Your Ref: OWPC25902
Our Ref: LU/36/20/HH 01-02-2020
Please ask for:
Zac Denton

Loft conversion with rear dormers.
2 Etherington Place Littlehampton

Thank you for your internet representation made on 4th March 2020 which has been recorded as '**an objection**' with the comments as follows:

Proposed Elevations

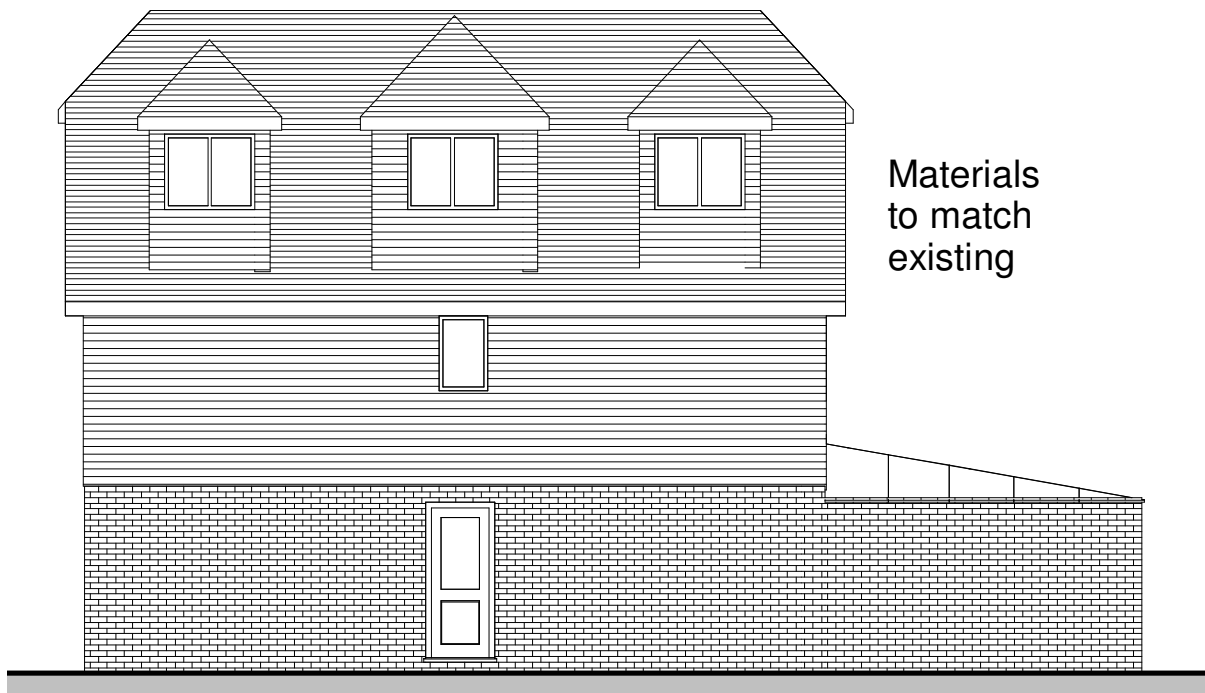
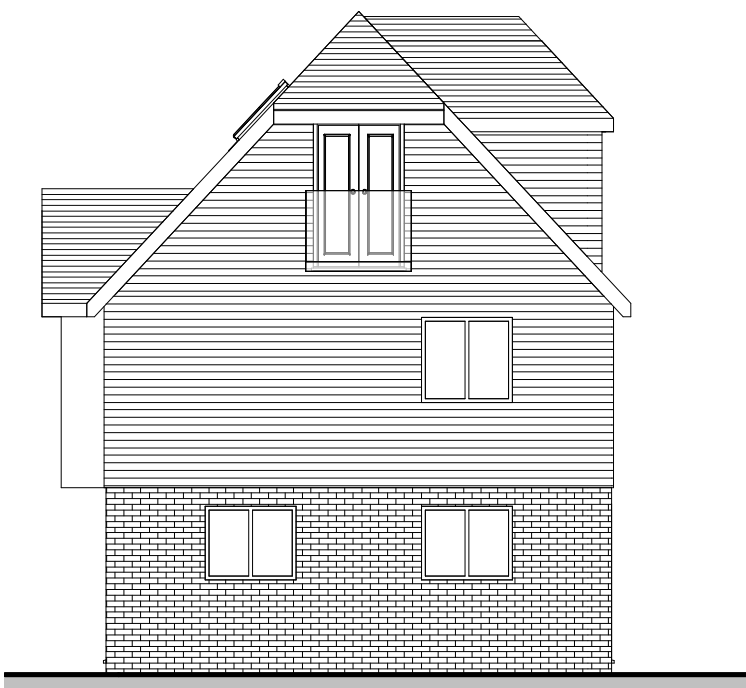
The Town Council's Planning and Transportation Committee considered this matter at its meeting held on Monday 2nd March 2020 and objected to the application. This was on the grounds that the proposed development is overbearing and out of character by virtue of its height and scale and would have a detrimental impact on the residential amenity of neighbours. This is contrary of the Arun Local Plan Policy DDM1 relating to aspects of form and design quality.
